Boston Alternative Energy Facility

Appendix D3 to Natural England's Deadline 5 Submission

Natural England's Advice on Outline Air Quality and Dust Management Plan [REP3-015] and Air Quality Deposition Monitoring Plan [REP4-016]

25th January 2022

**BOSTON ALTERNATIVE ENERGY FACILITY**  
**DEVELOPMENT CONSENT ORDER**  
**Regulation 5(2)(o) Overview of Statutory and Non Statutory Sites**  
**and Features of Nature Conservation and Habitats Plan**  
**BOSTON BOROUGH COUNCIL - Sheet 1 of 1**

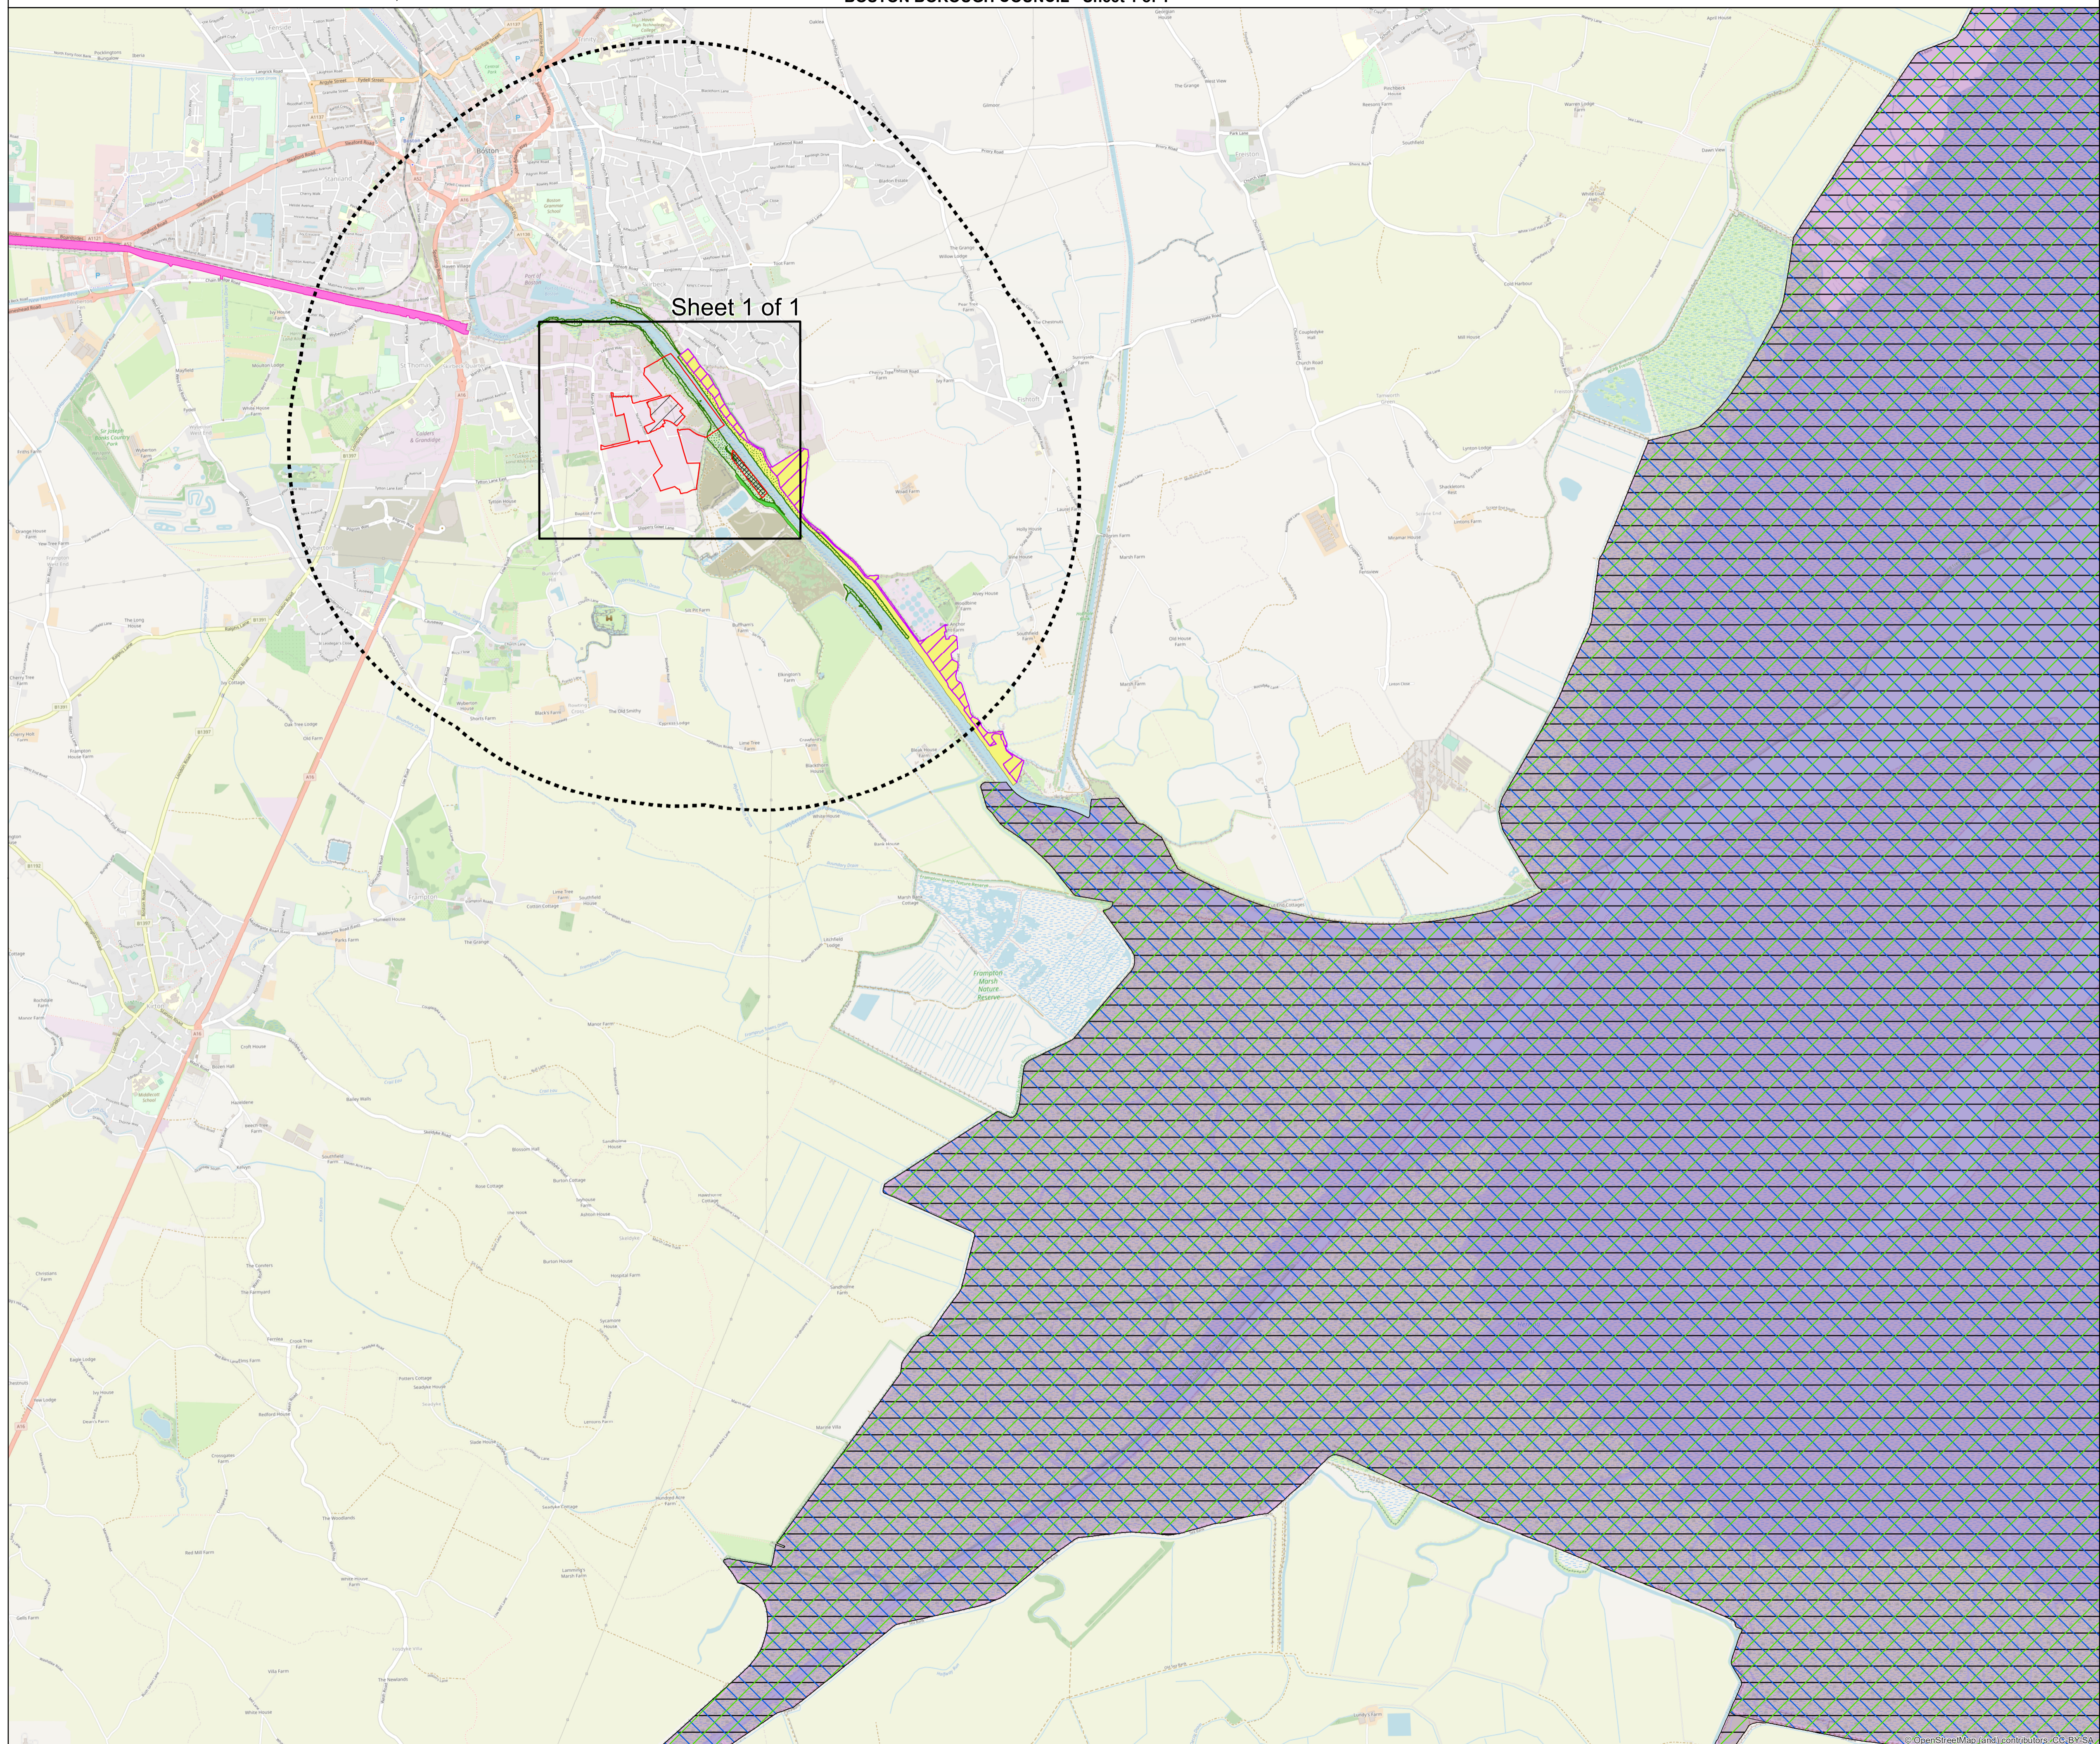
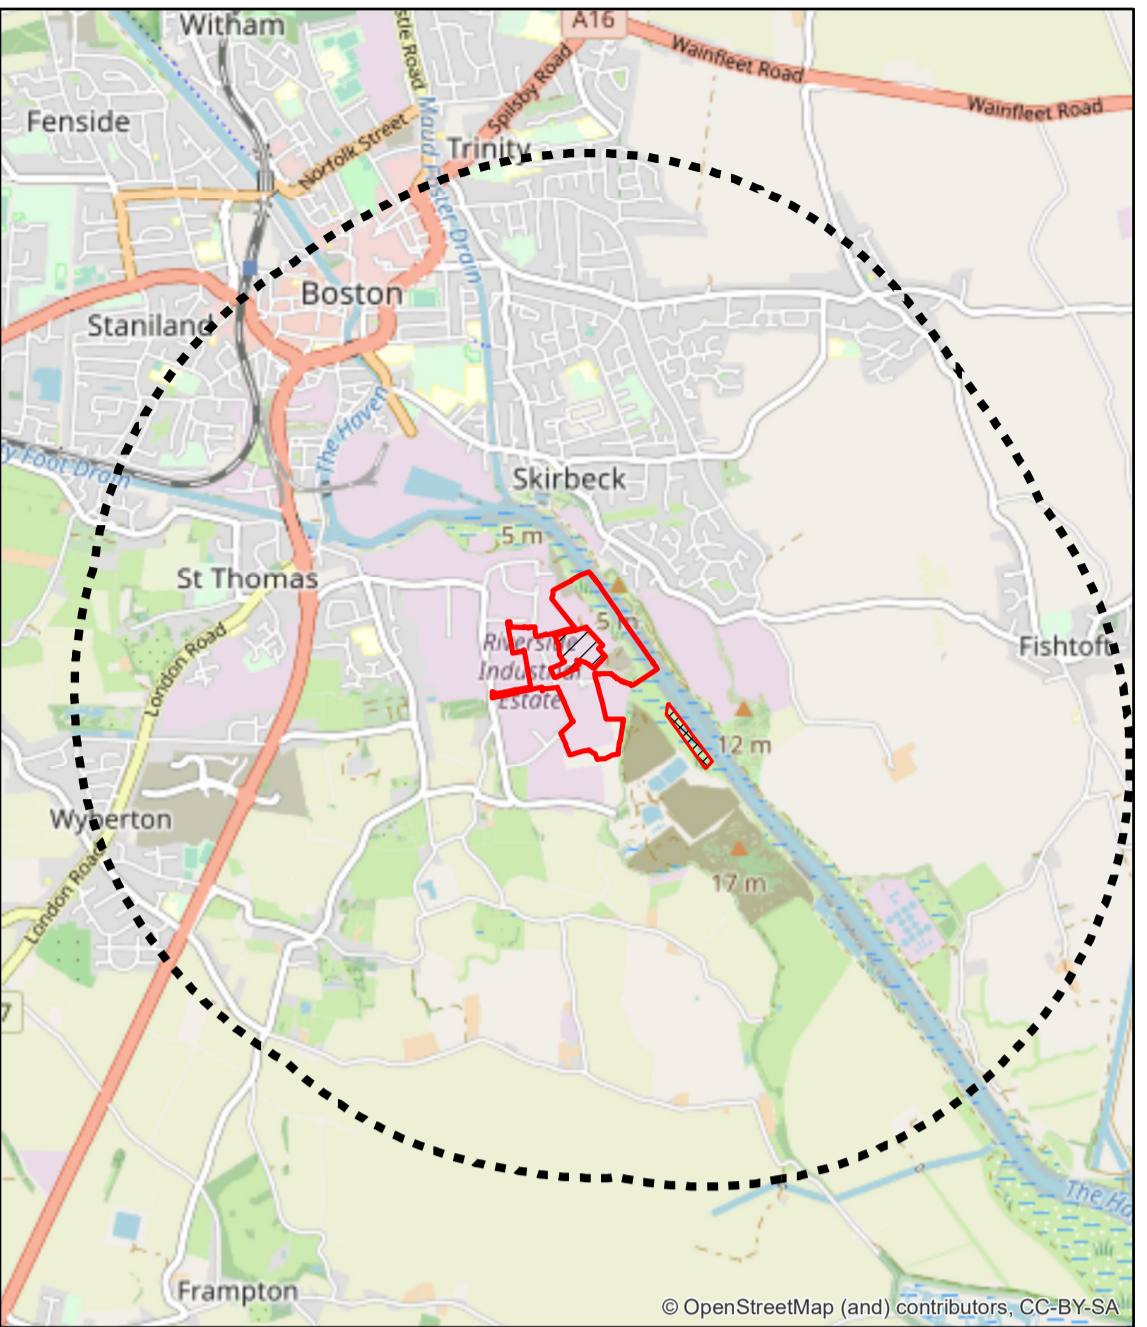
NE Risk and Issues Log Comment	Comment	RAG status
4.	Whilst dust impacts during construction are considered at Havenside LNR; what about on the area of saltmarsh being used for the Habitat Mitigation Area? This needs to be considered.	NE advises that the Applicant is still to confirm that the dust impact mitigation measures and monitoring will also be in place at this receptor site.
